**PROPOSED RESIDENTIAL DEVELOPMENT
PARK WEST AVENUE, CHERRY ORCHARD,
DUBLIN 10**

Stage 1 Quality Audit

**(Incorporating a DMURS Street Design Audit, and Audits
of Accessibility, Cycling, Walking and Road Safety)**

**DUBLIN CITY COUNCIL &
LAND DEVELOPMENT AGENCY**

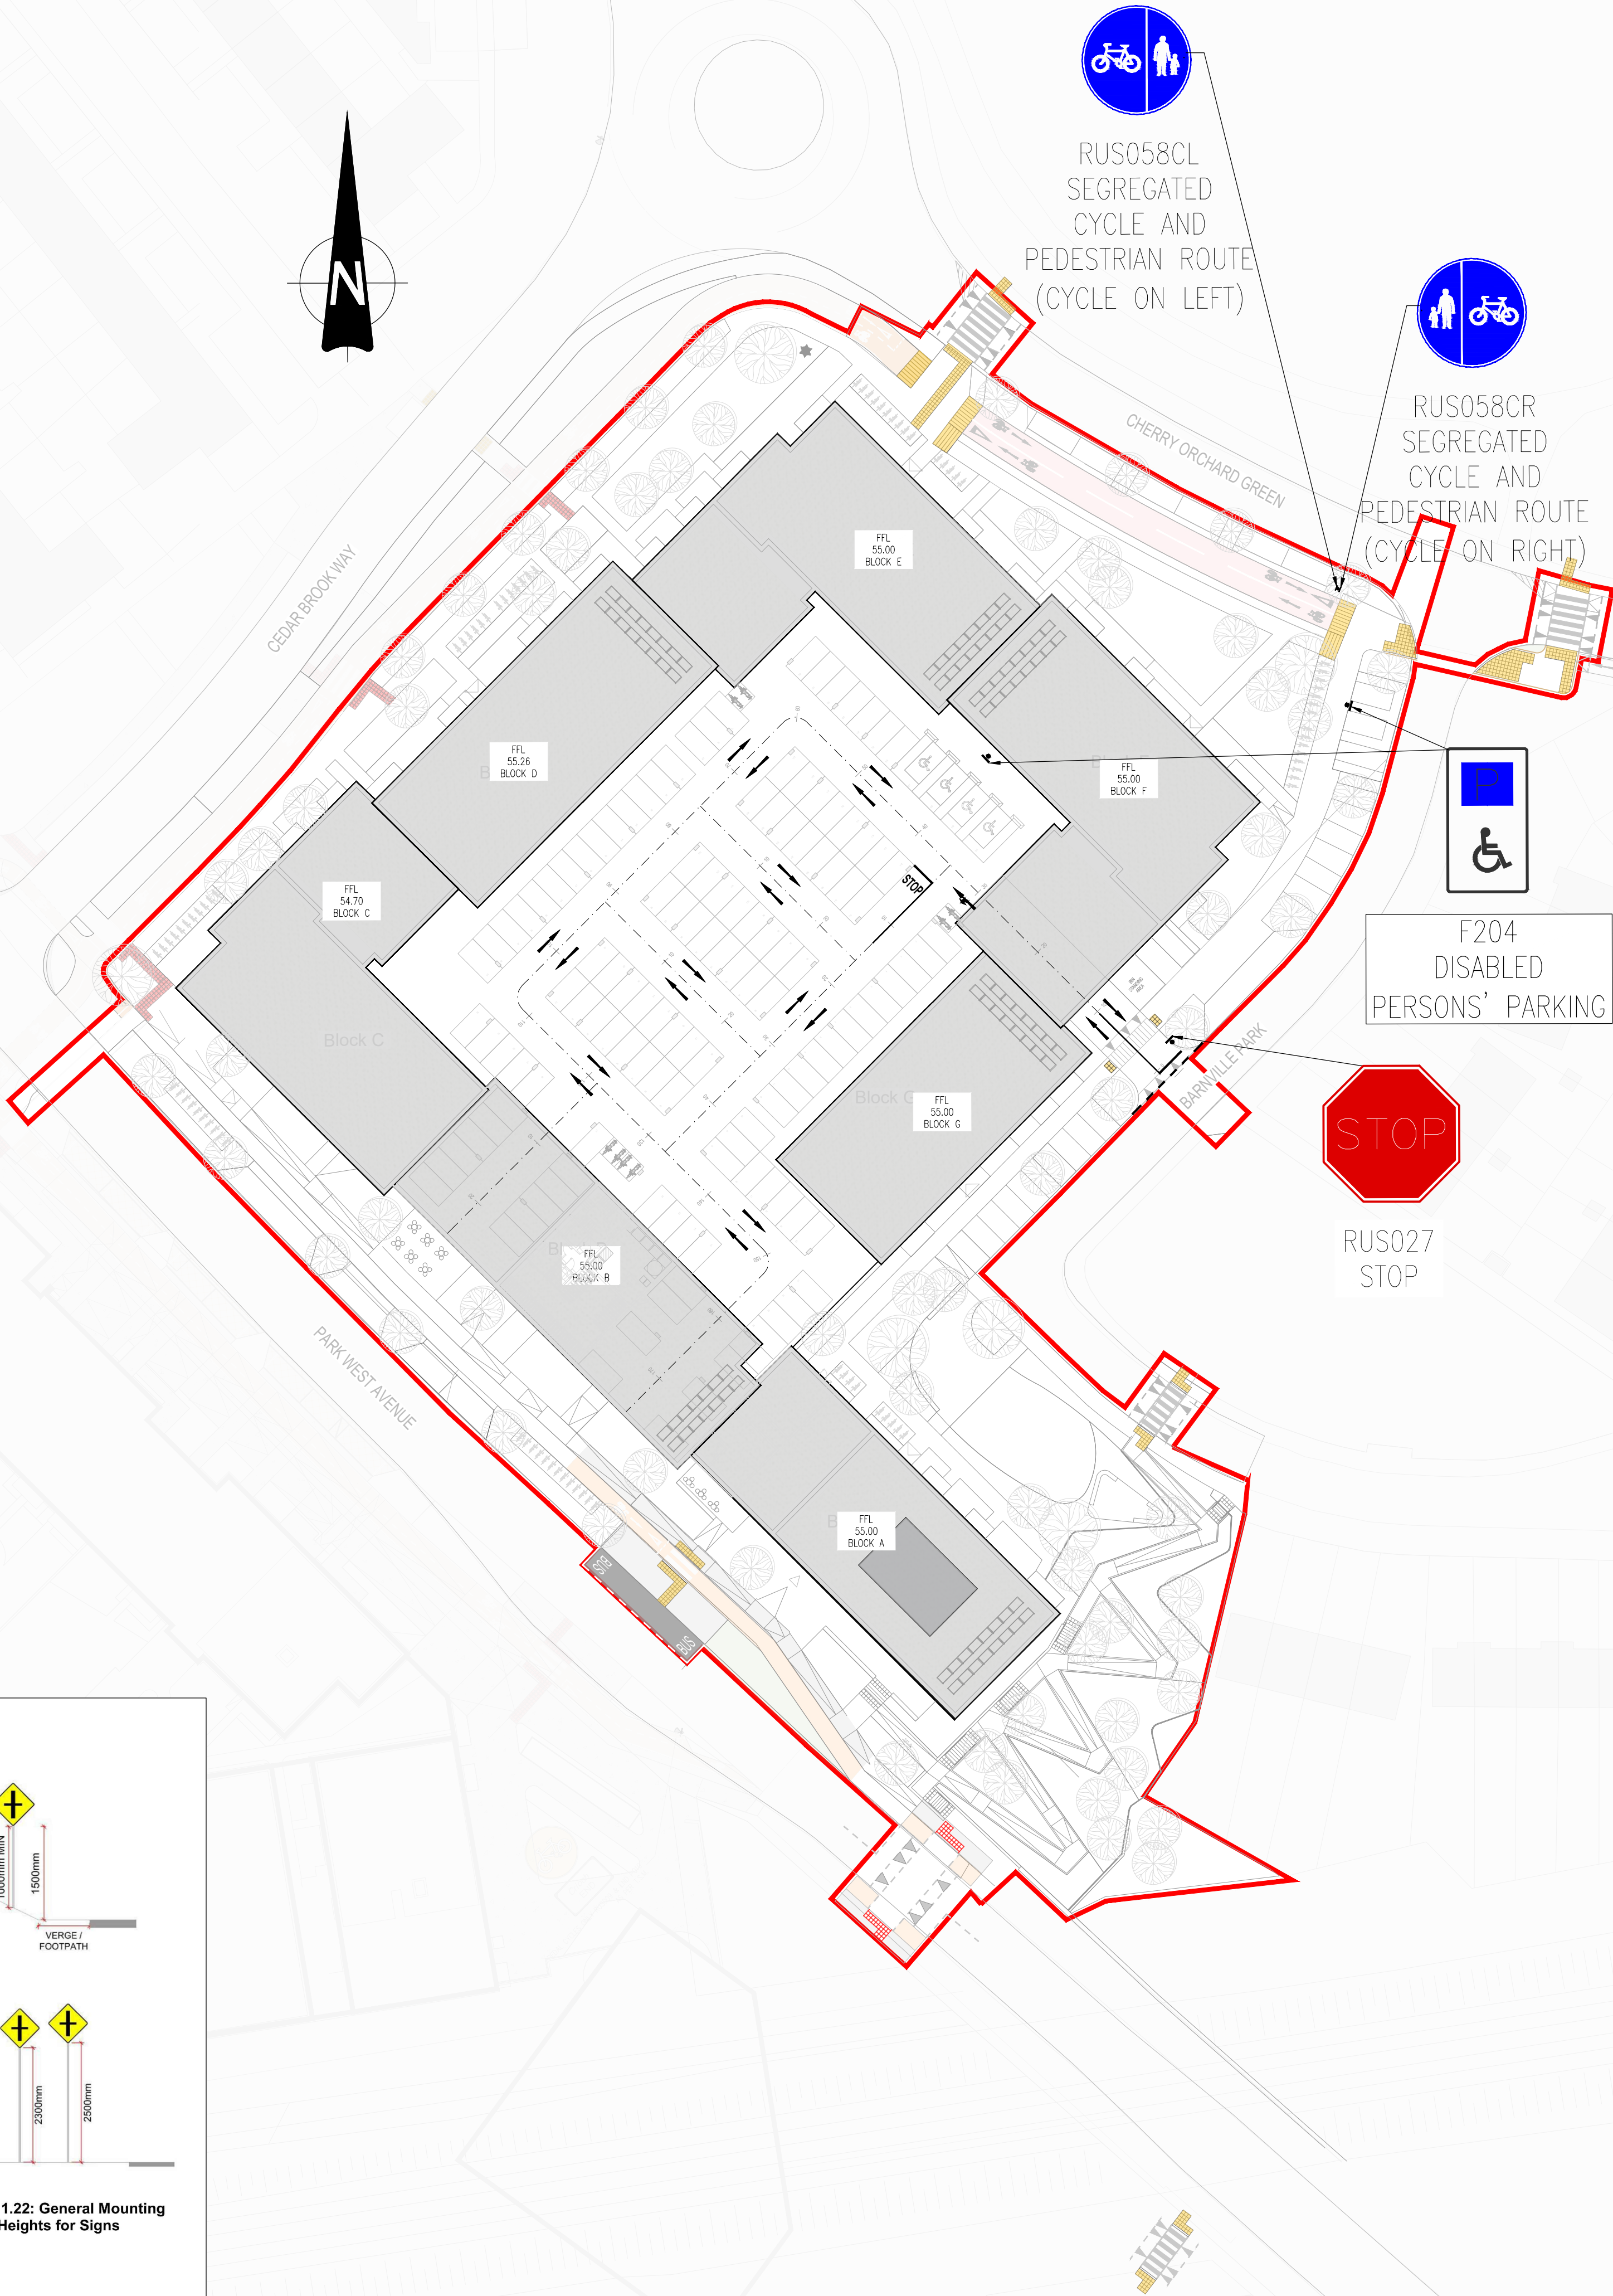
Priority arrangements at the internal junctions within the proposed car parking area are not indicated on the drawings. The absence of clearly defined priority may result in uncertainty among drivers regarding right-of-way, leading to hesitation, inappropriate manoeuvres, or conflicting vehicle movements. This could increase the risk of vehicular collisions and may also present a hazard to pedestrians moving through the car parking area.

Provide appropriate road markings at the internal junctions within the car park area.

5.8	YES	YES	Appropriate road markings and priority junctions have been included in the updated design and are reflected in the roads markings and signage drawings submitted under the planning application.	-----

The existing Cherry Orchard Green / Barnville Park junction is not provided with road markings. The absence of appropriate road markings may result in uncertainty regarding junction priority and vehicle positioning, which could lead to driver confusion, inappropriate manoeuvres, and an increased risk of collisions.

Provide appropriate road markings at the existing Cherry Orchard Green / Barnville Park junction.

5.2	YES	YES	There is currently no stop line at this junction. This can be added if required by Dublin City Council.	-----
5.3	YES	YES	The lack of visibility within the visibility splays at the proposed access location to the undercroft parking is acknowledged. The parking spaces along Barnville Park have been shifted to avoid encroachment into the visibility splay. The updated visibility splays are reflected in the current visibility splay drawings.	-----

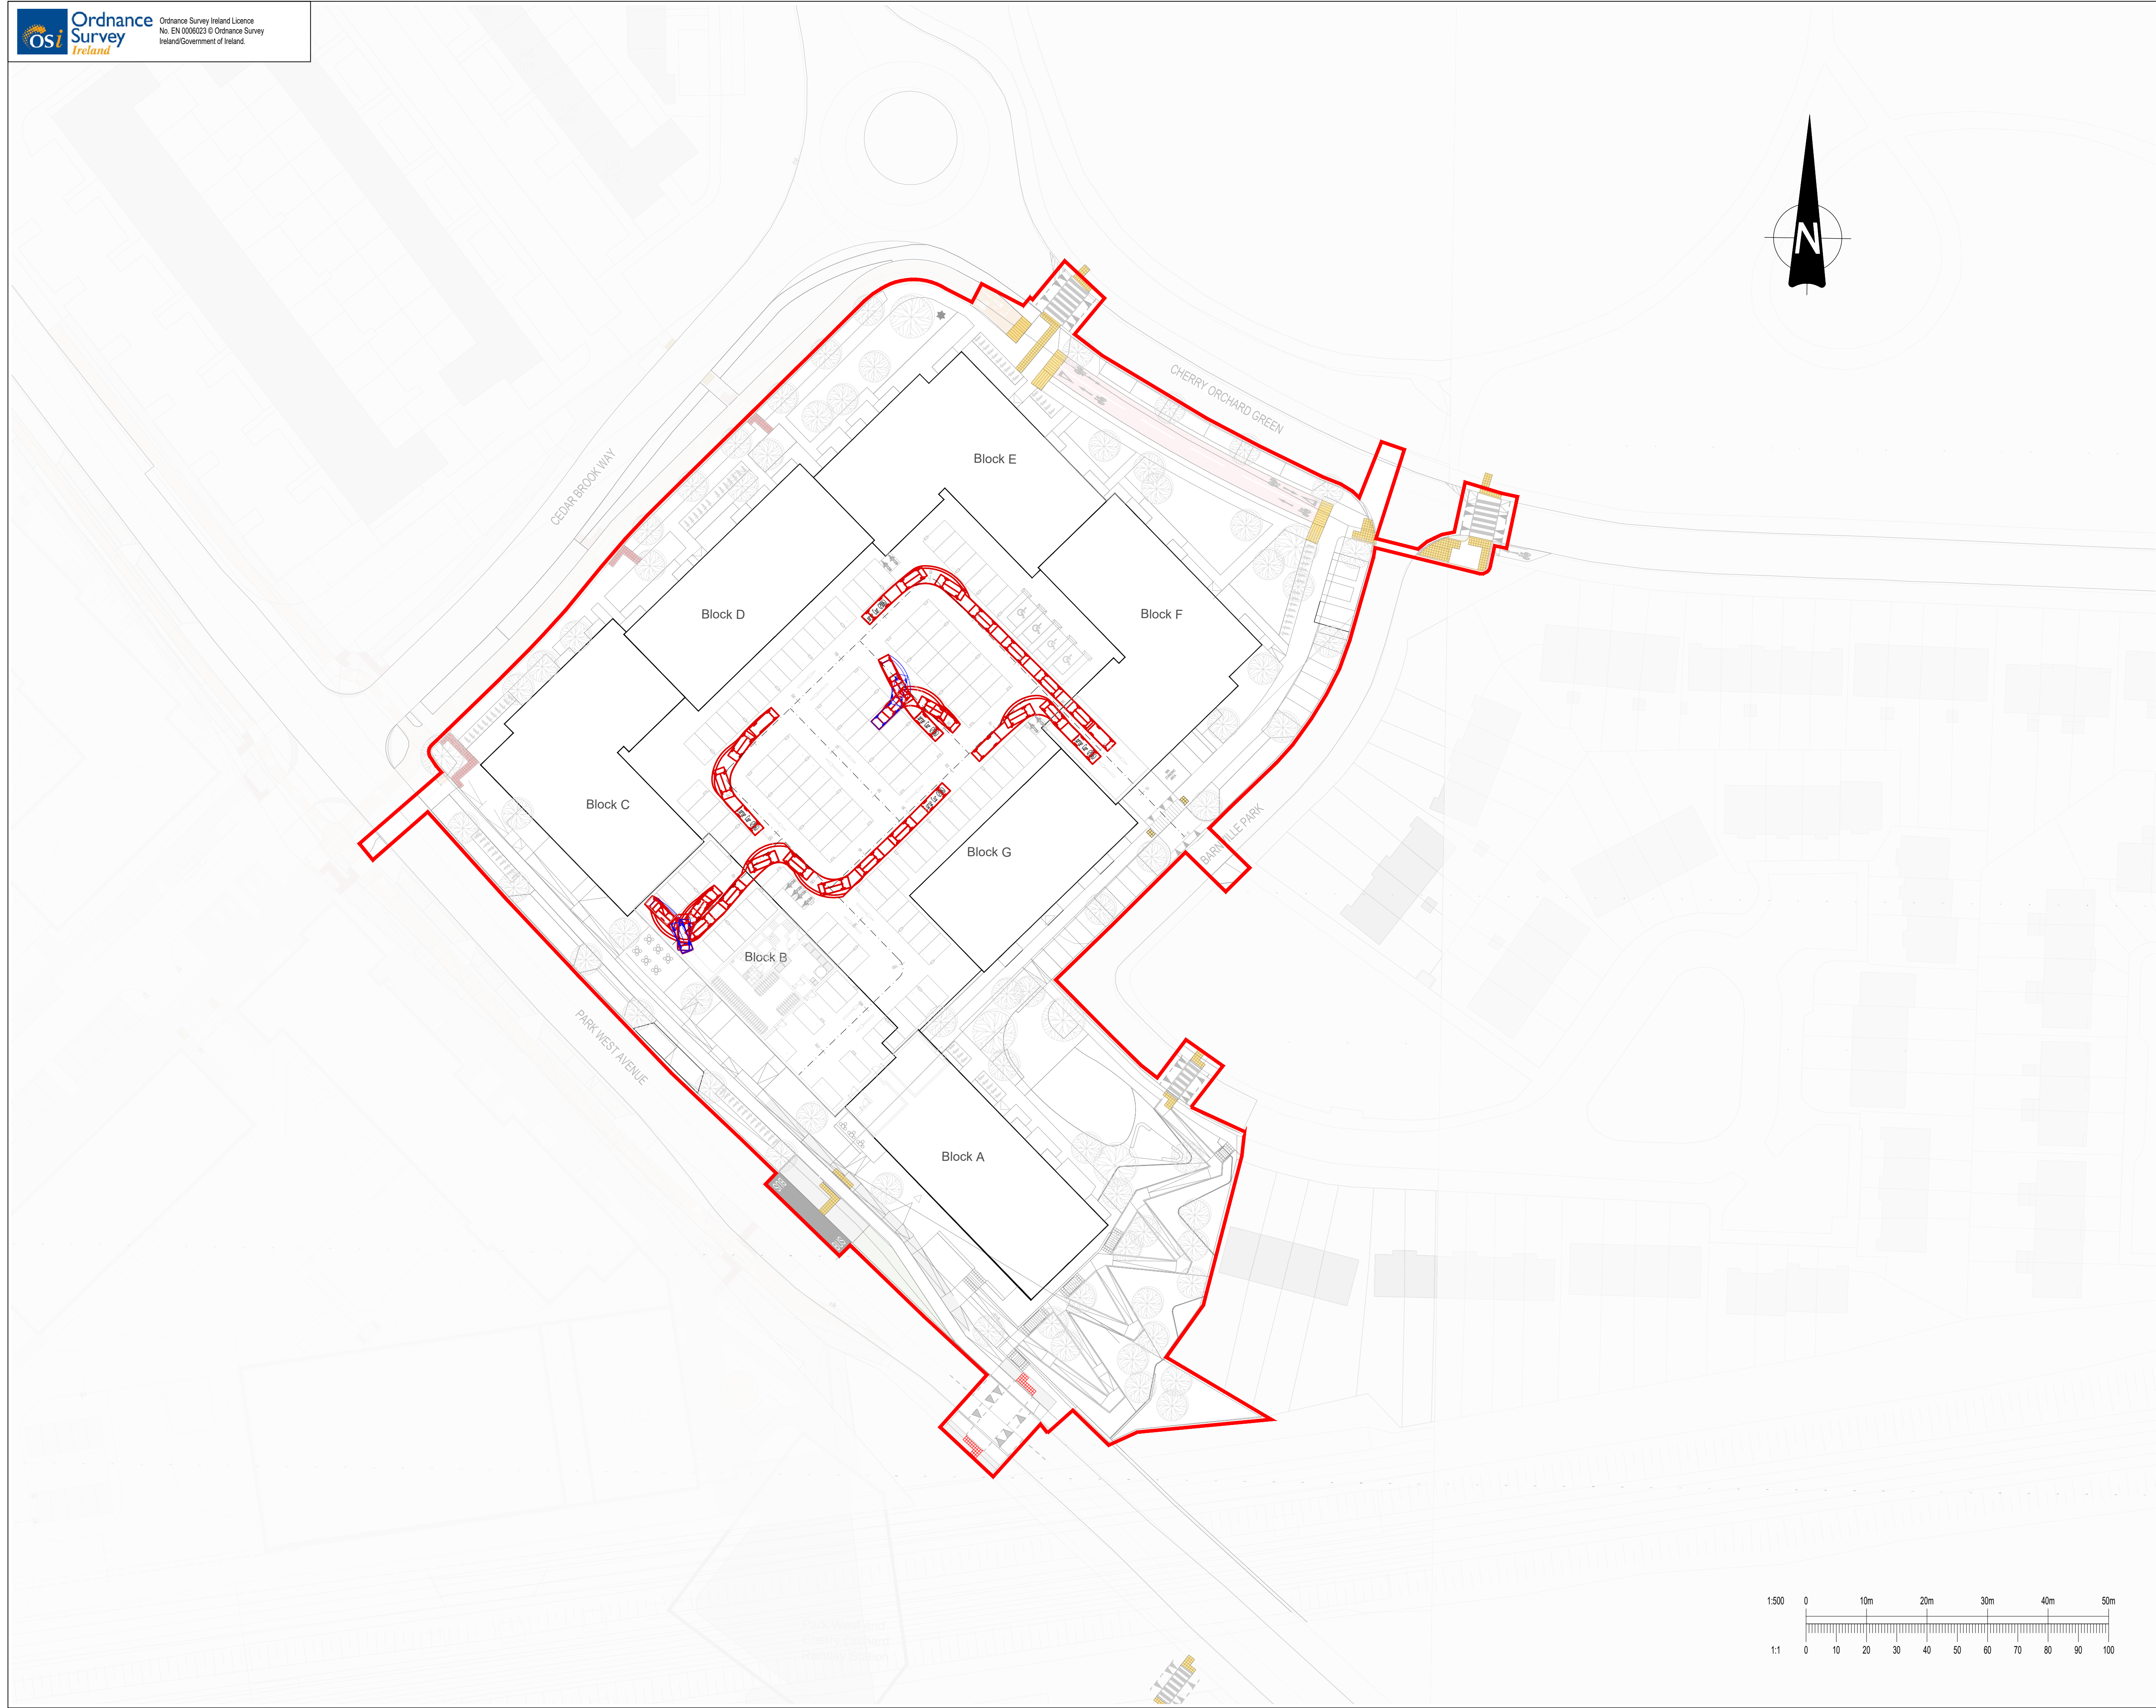
Swept Path Analysis drawings have been provided for certain vehicle movements; however, they do not demonstrate vehicle manoeuvrability throughout the proposed internal car park. As a result, it is unclear whether sufficient space is available for all vehicles to manoeuvre safely within the development. Inadequate manoeuvring space may result in encroaching into opposing traffic lanes or pedestrian areas, or undertaking multi-point turns, increasing the risk of vehicular collisions and injuries to vulnerable road users

Ensure adequate manoeuvrability space on all road networks for all vehicle types.

5.6	YES	YES	Swept path analysis for a large vehicle within the undercroft parking area has been included in the planning application drawing pack	-----

and clearly demonstrates the manoeuvrability of vehicles within the undercroft. Refuse and fire tender vehicles are not proposed to access or utilise the undercroft parking area.
